KITTITAS COUNTY

MEMORANDUM

TO: Kaycee Hathaway, Community Development Services
FROM: Christina Wollman, Planner III *CW*
DATE: December 22, 2015
SUBJECT: Anderson BL-15-00016

The Public Works Department has reviewed the Request for Boundary Line Adjustment Application. In order to ensure that it meets current Kittitas County Road Standards, the applicant needs to provide the following prior to final approval:

ANDERSON PROPERTY

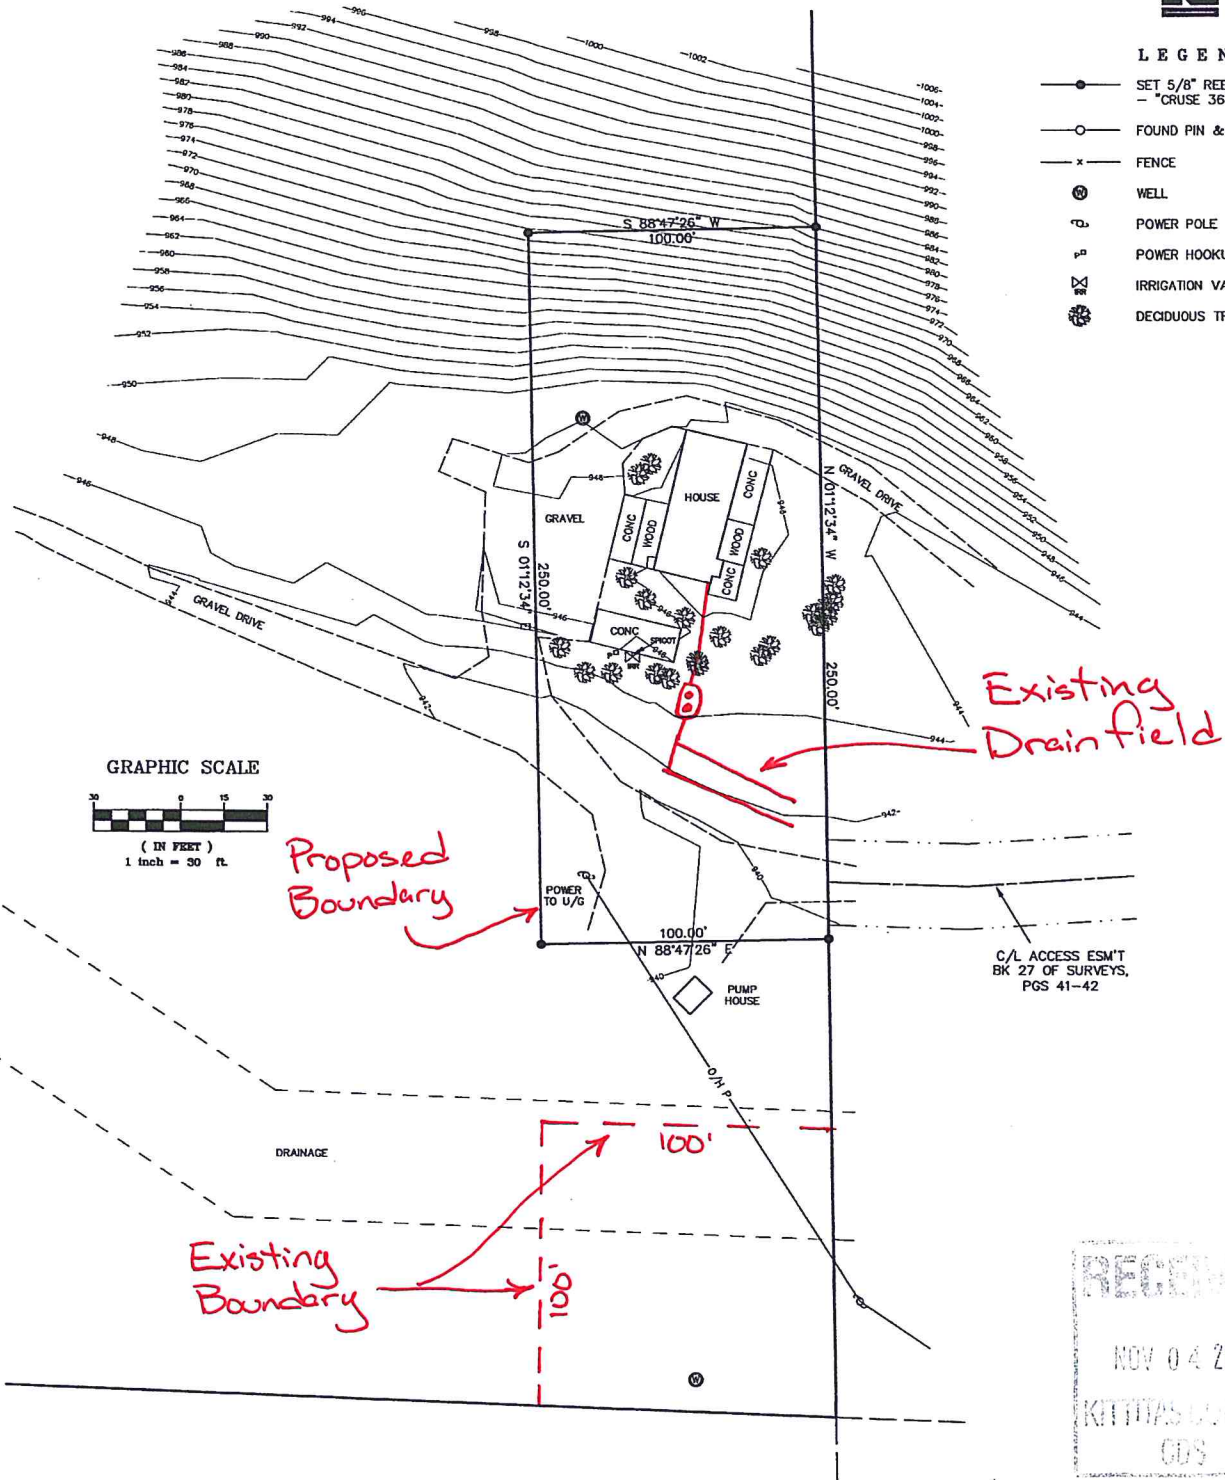
1. An extension of the easement to serve both parcels is required.
